# FOURSQUARE AT STERLING RANCH EAST FILING NO. 1

# V3\_Plat.pdf Markup Summary

FOURSQUARE AT STERLING RANCH EAST FILING NO. 1
 JOB NO. 1183.23
 NOVEMBER 9, 2022
 SHEET 1 OF 6

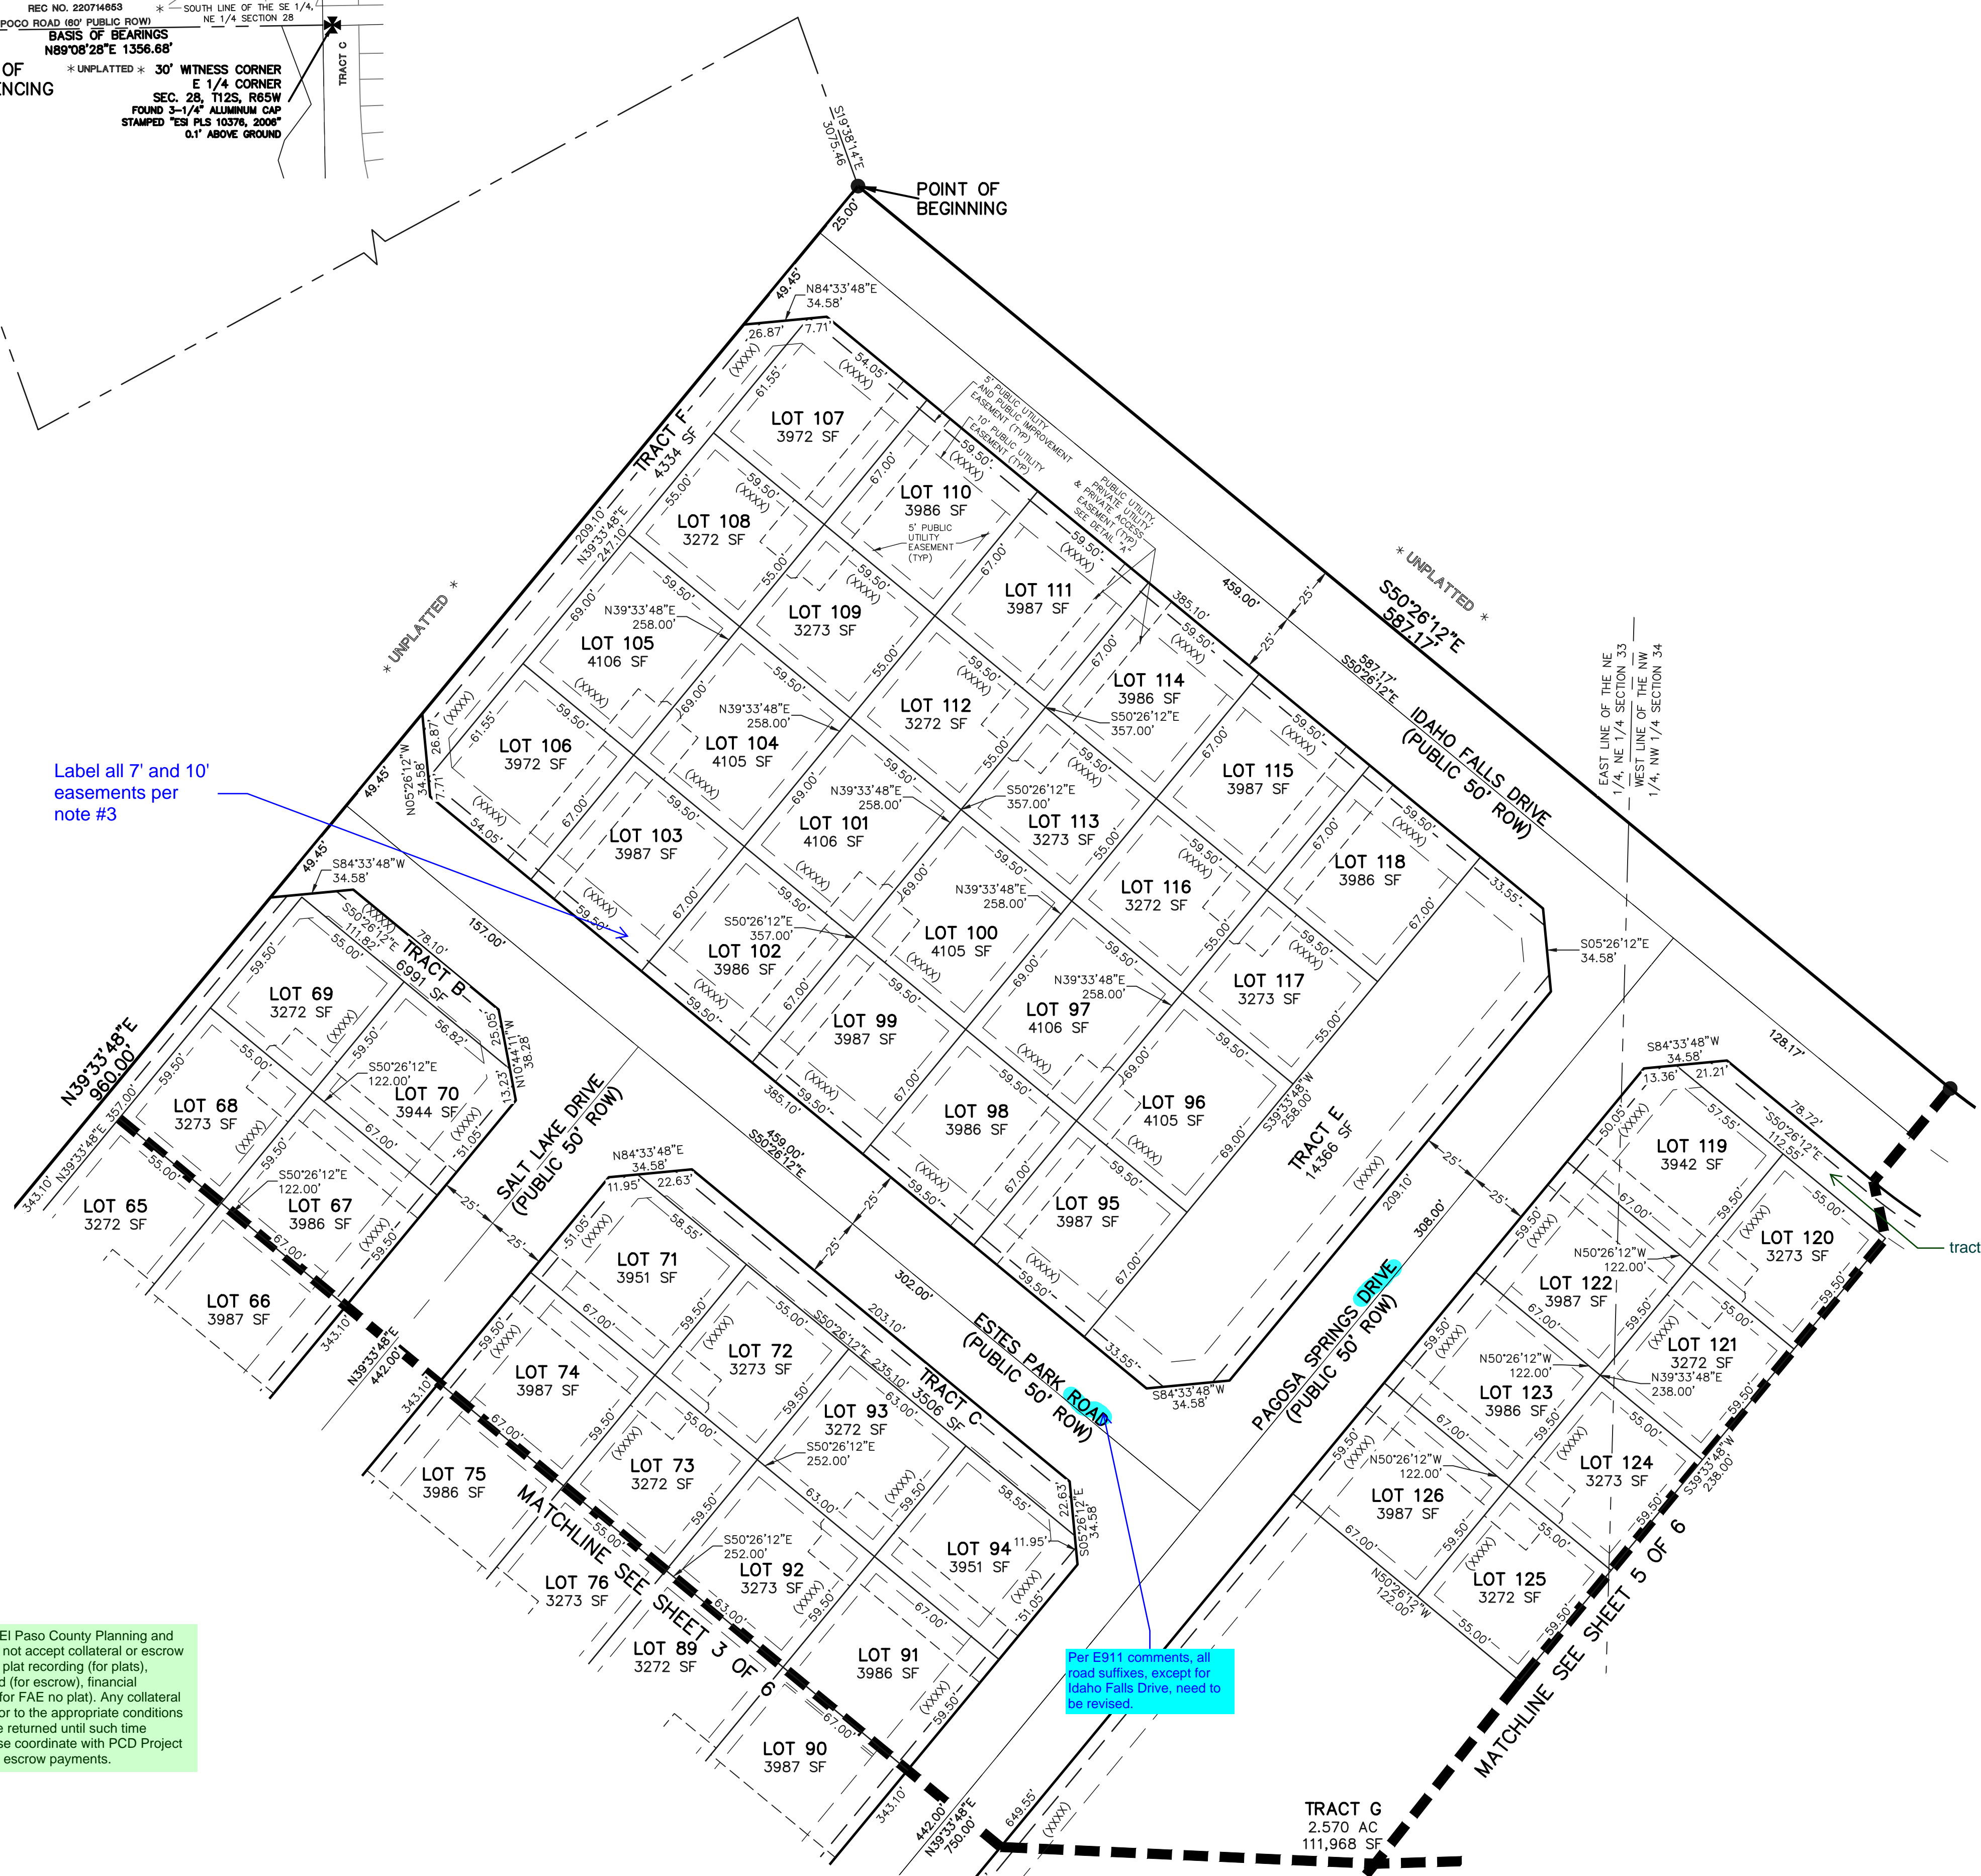
to be installed by developer to the edge of lots

NEW Policy- ALL PLATS will be required to identify the utility providers and state that the developer shall install the utilities to the edge of the lot.... (WELL AND SEPTC excluded) . Utilities are not collateralized.

Add: "This property is subject to a groundwater underdrain license agreement recorded under Reception No. \_\_\_\_\_ of the records of El Paso County."

FOURSQUARE AT STERLING
RANCH EAST FILING NO. 1
JOB NO. 1183.23
NOVEMBER 9, 2022
SHEET 6 OF 6

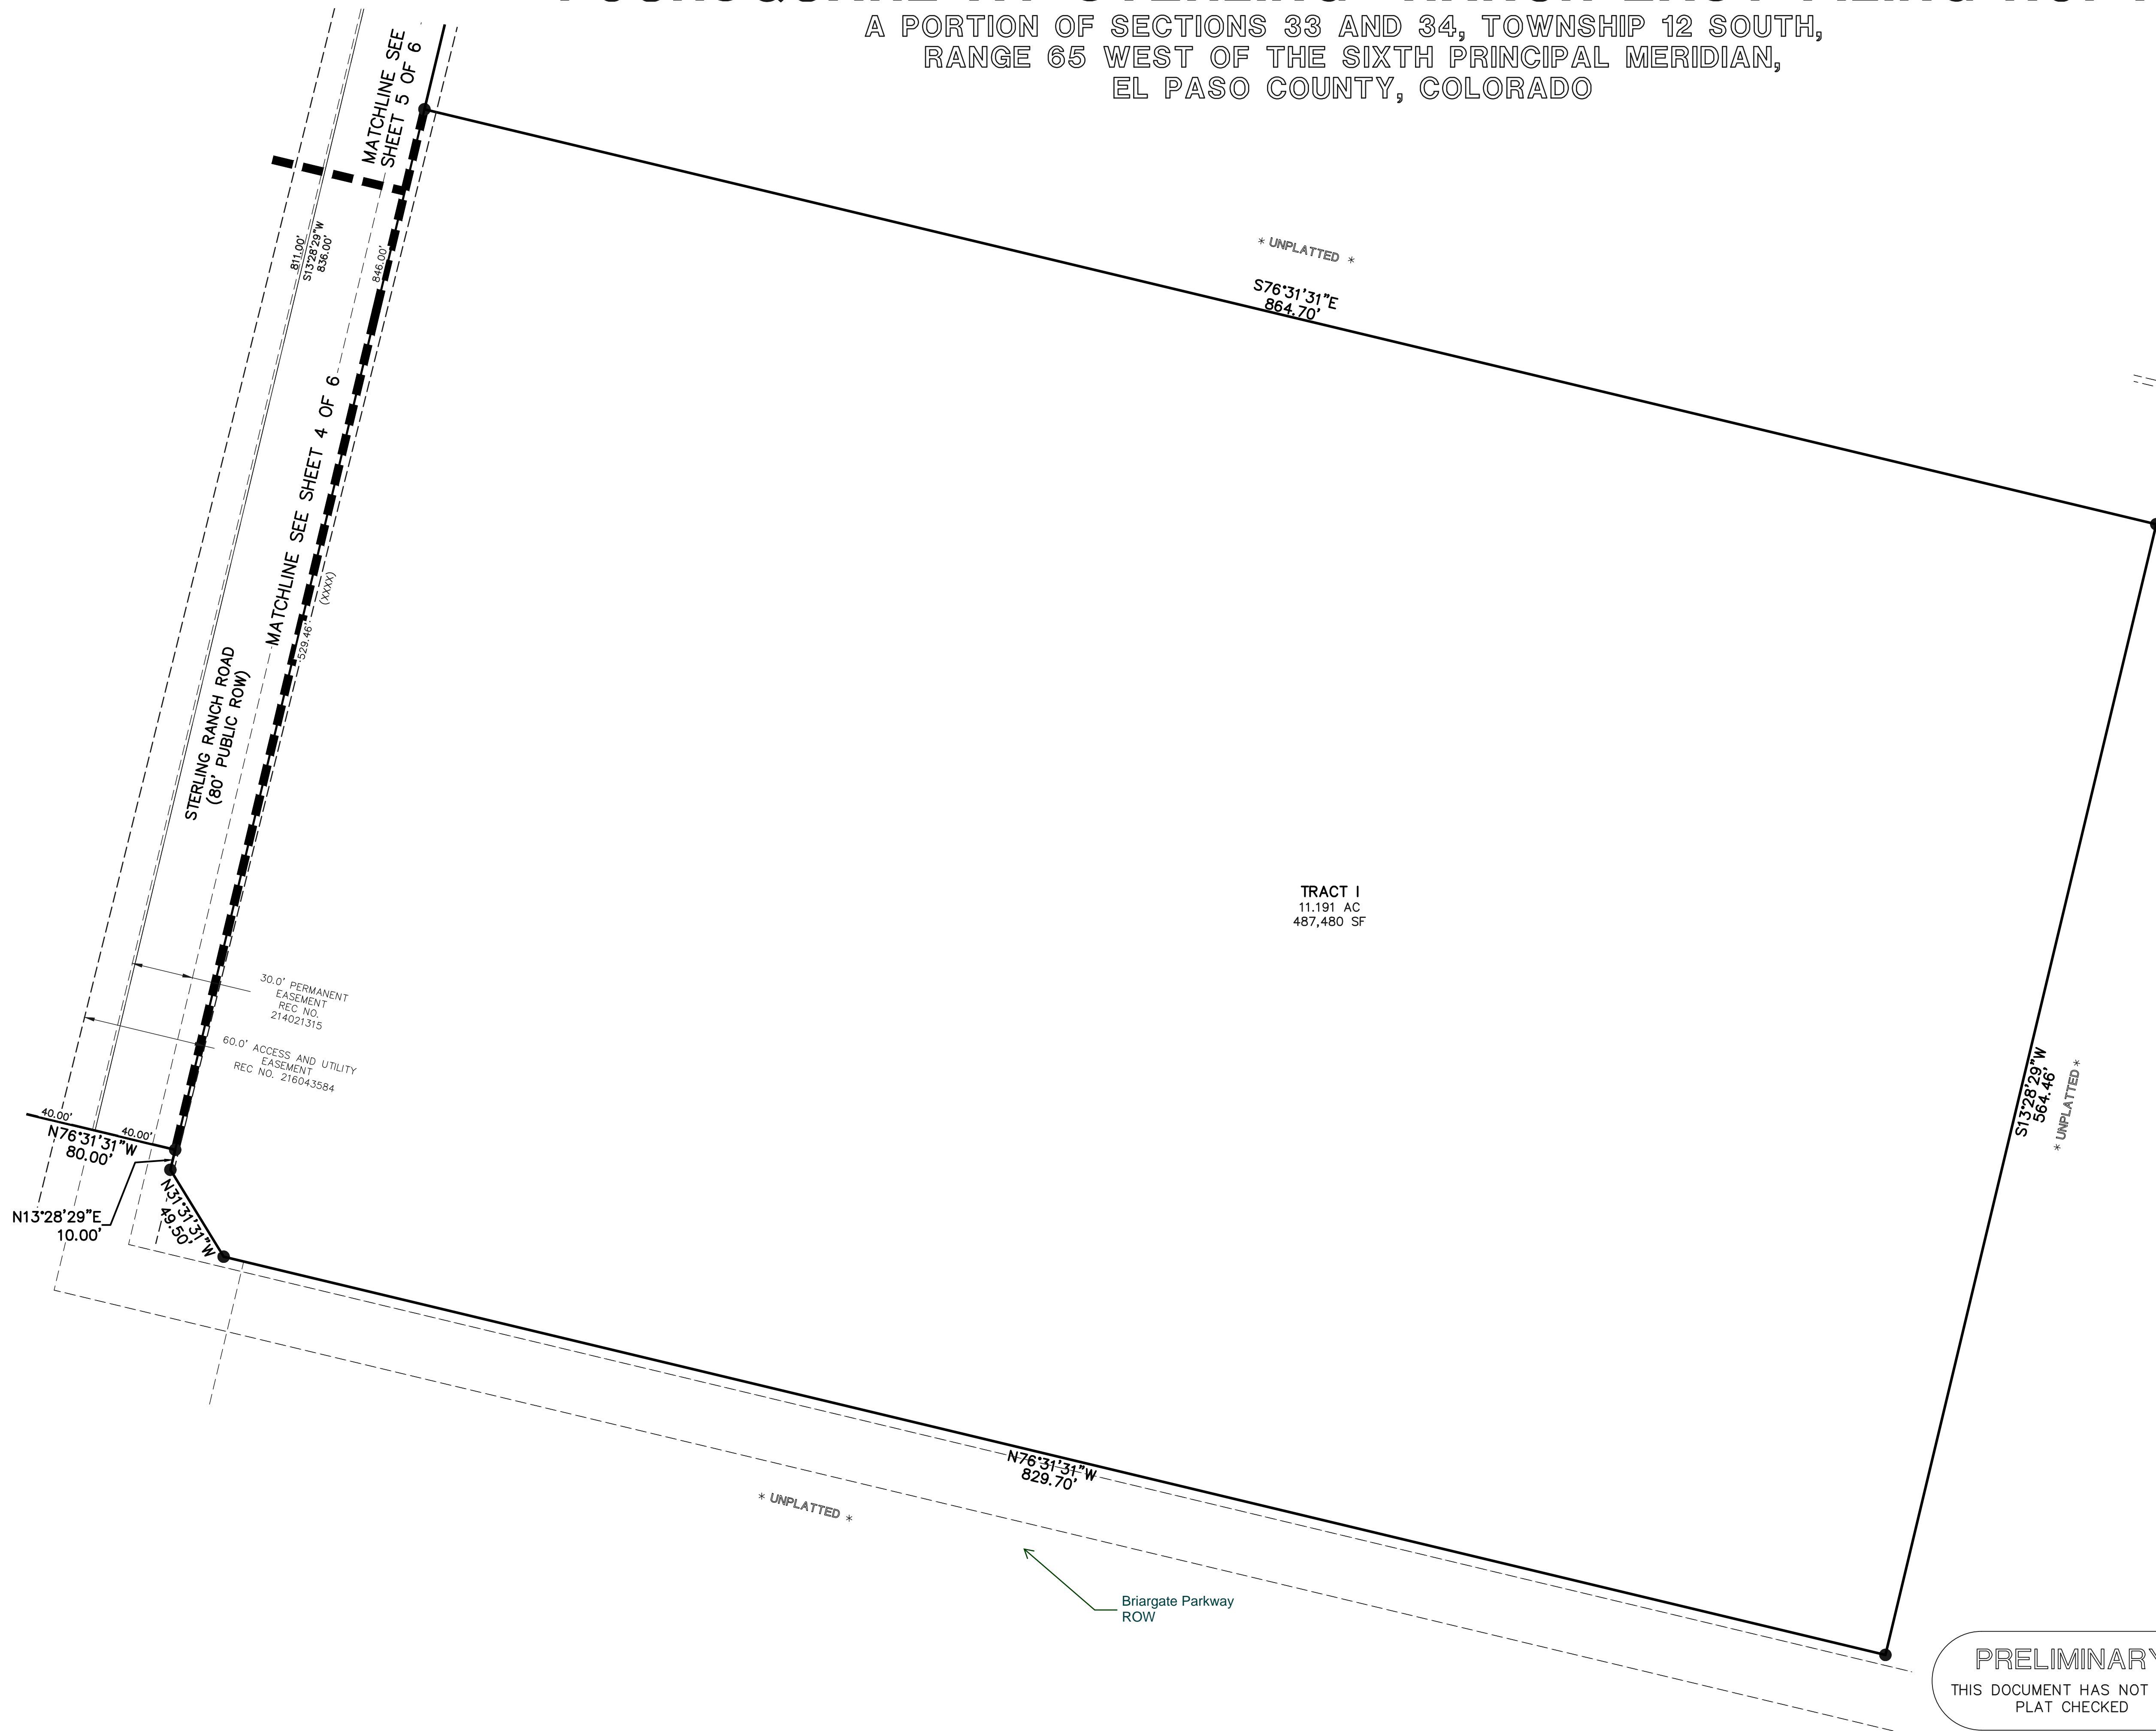
Complete labeling. Is this a separate tract or ROW?
